September 30, 2013
File: 13105

RE: 133 YORK STREET
RESPONSE TO DAVID SENUS, P.E., MEMO DATED AUGUST 27, 2013

C2.4

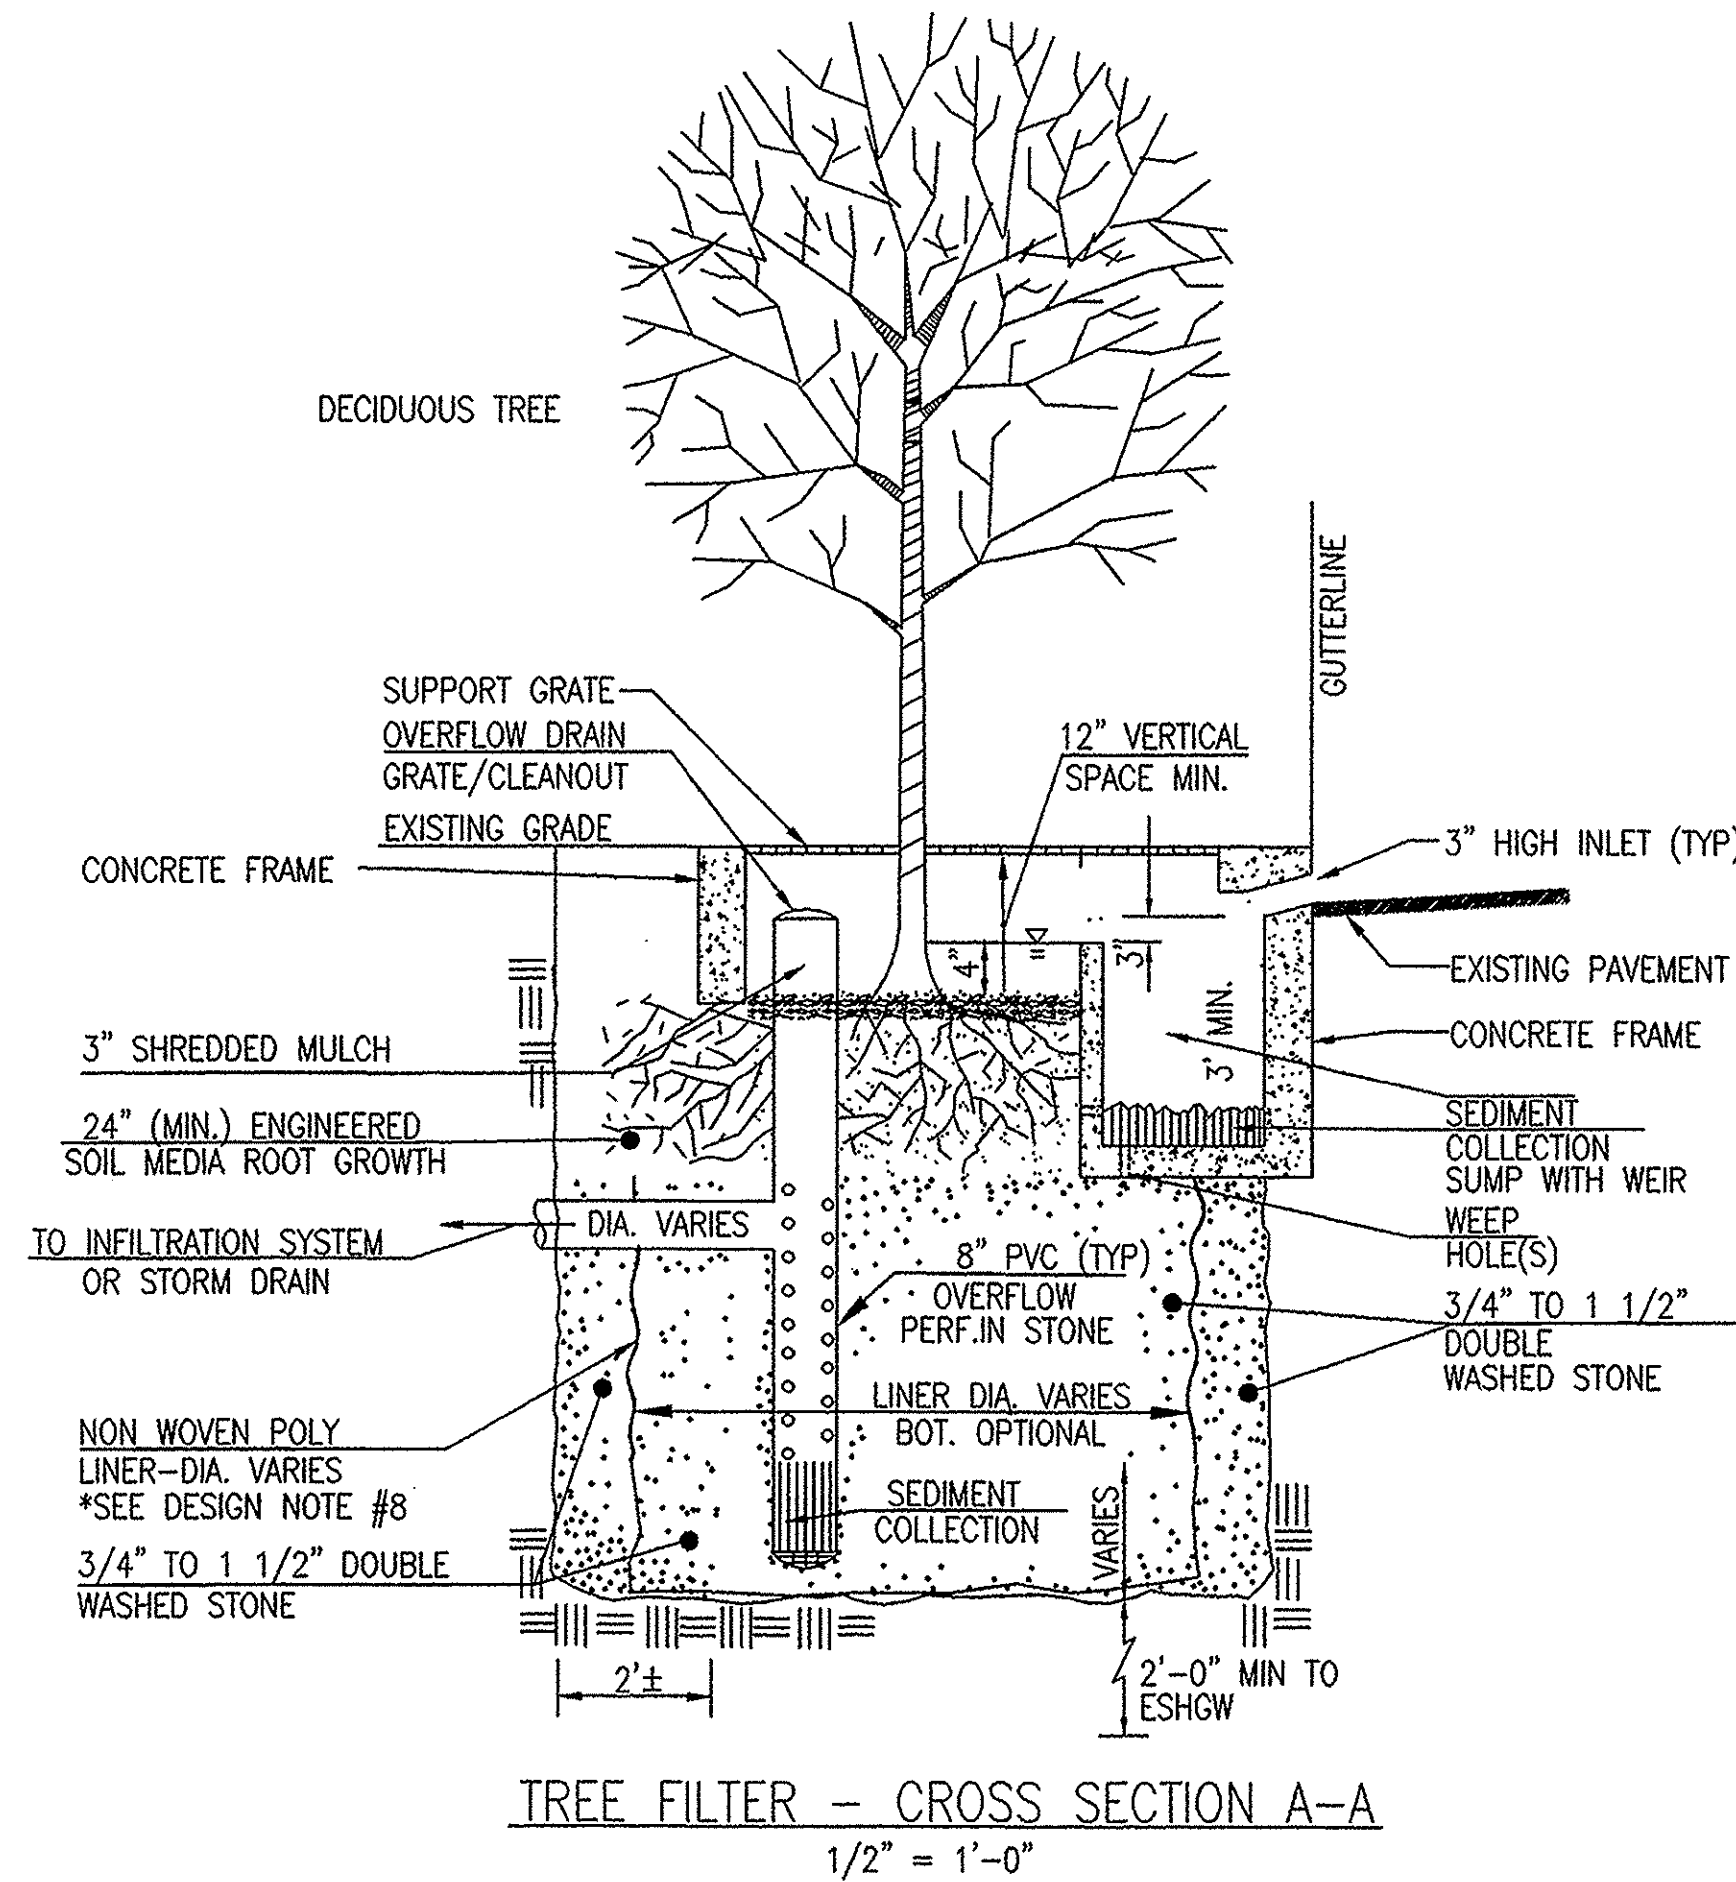
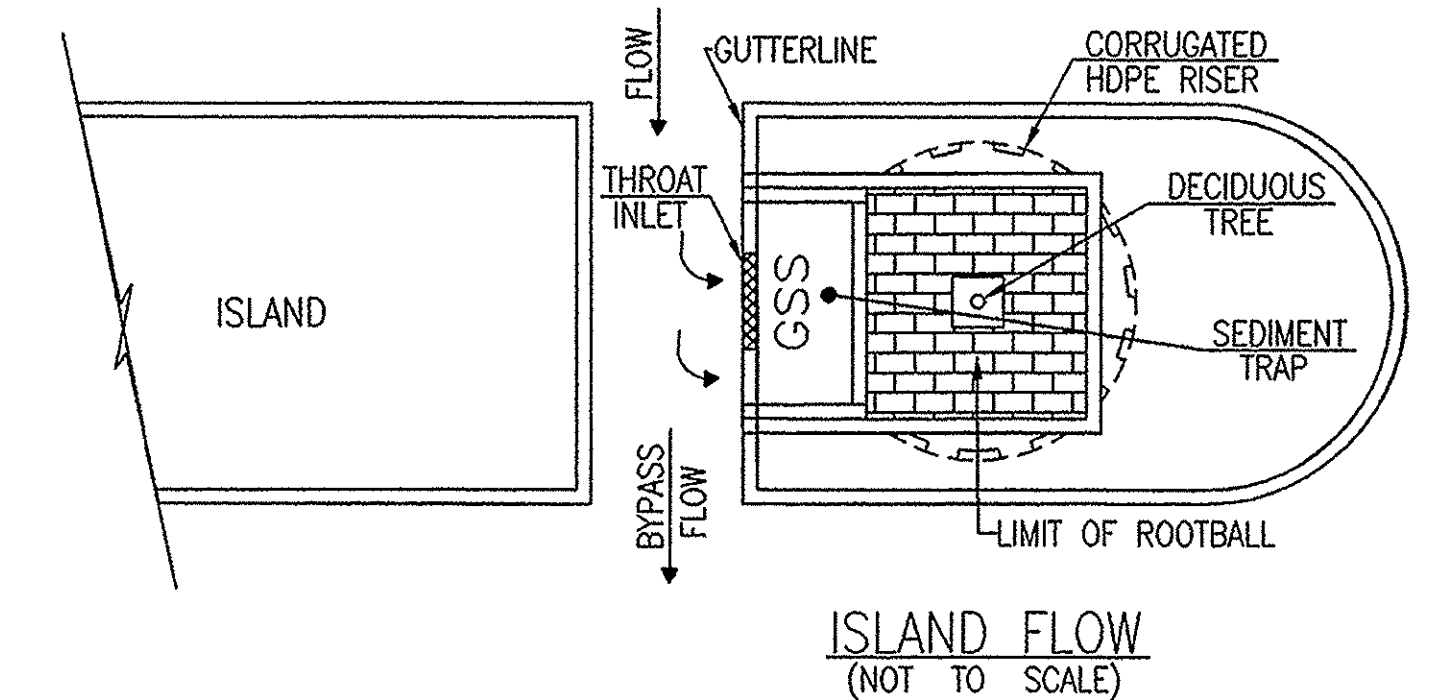
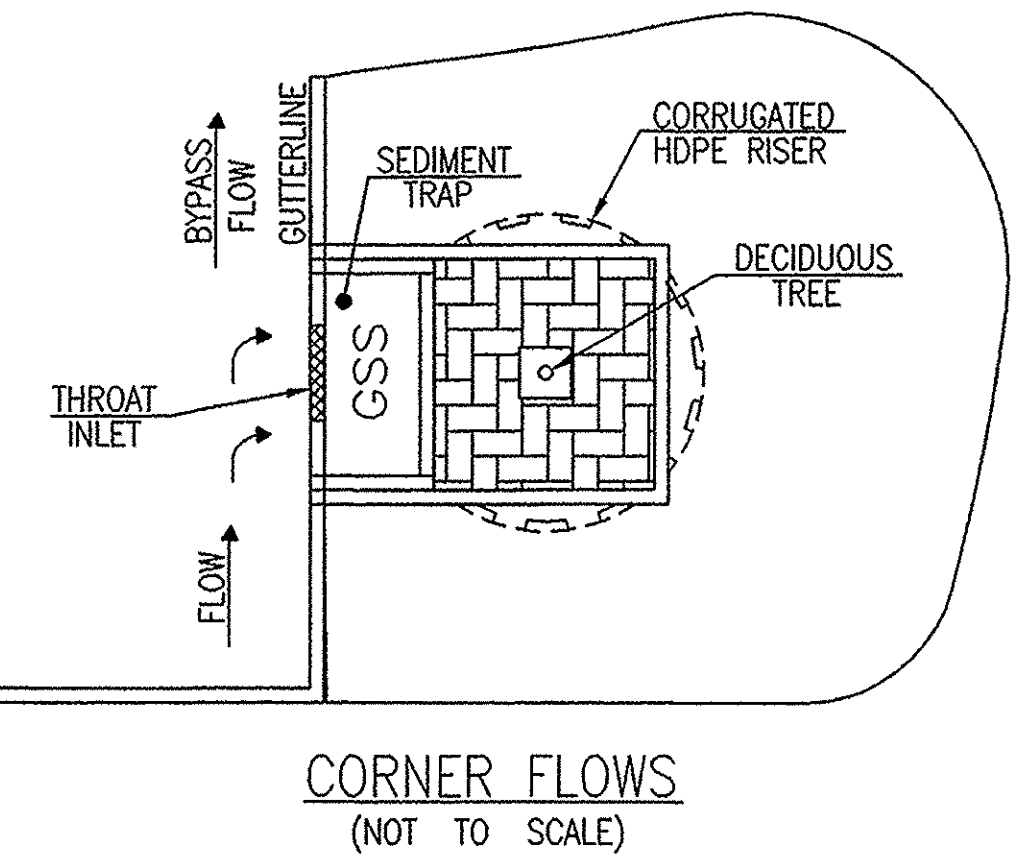
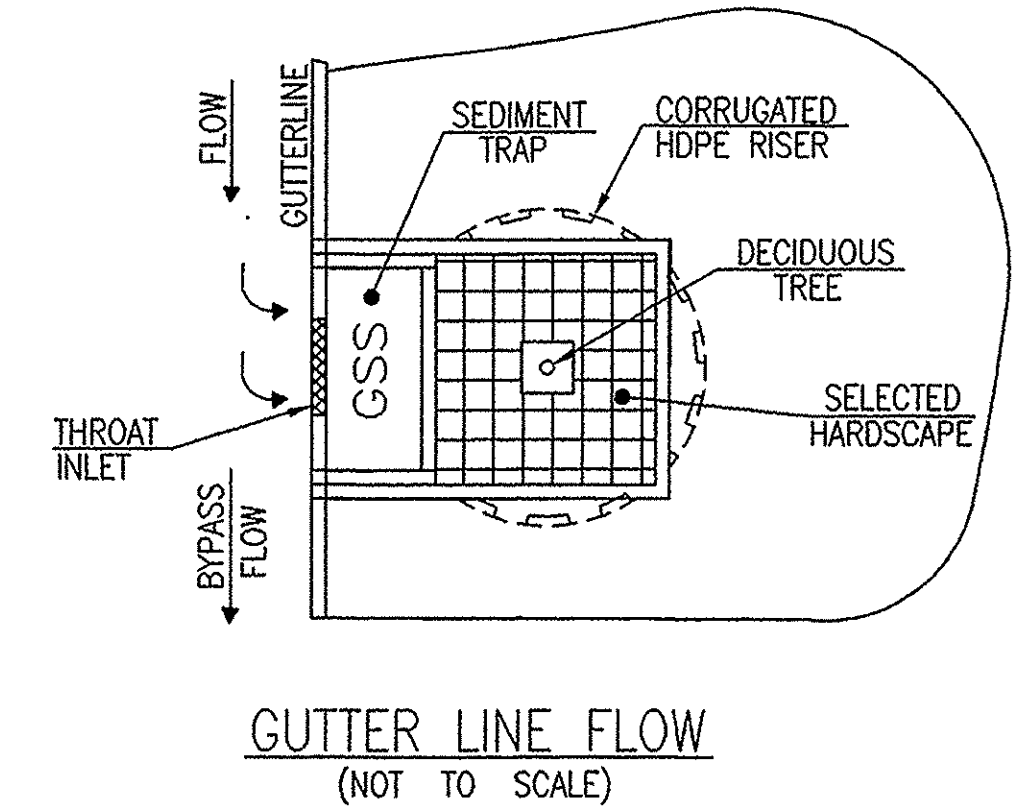
b) *General Standard: The Applicant has proposed a stormwater tree well to treat runoff from an impervious area in excess of the proposed new impervious area; the approach meets the intent of the General Standards. The Applicant should provide calculations on the sizing and design of the tree filter system, and clarify the system dimensions on Tree Filter detail sheet.*

4. *Provide additional information related to the roof drain connection to the treewell filter and the treewell filter connection to the site's storm drain system (provide pipe sizes, invert elevations, and detail the connections to the tree filter).*

We have added details on the tree filter to the drawings. We have removed the roof drain from the filter at the recommendation of Tree Filter's manufacturer. Attached are calculations for the tree filter.

The details of the drainage connections have been provided.
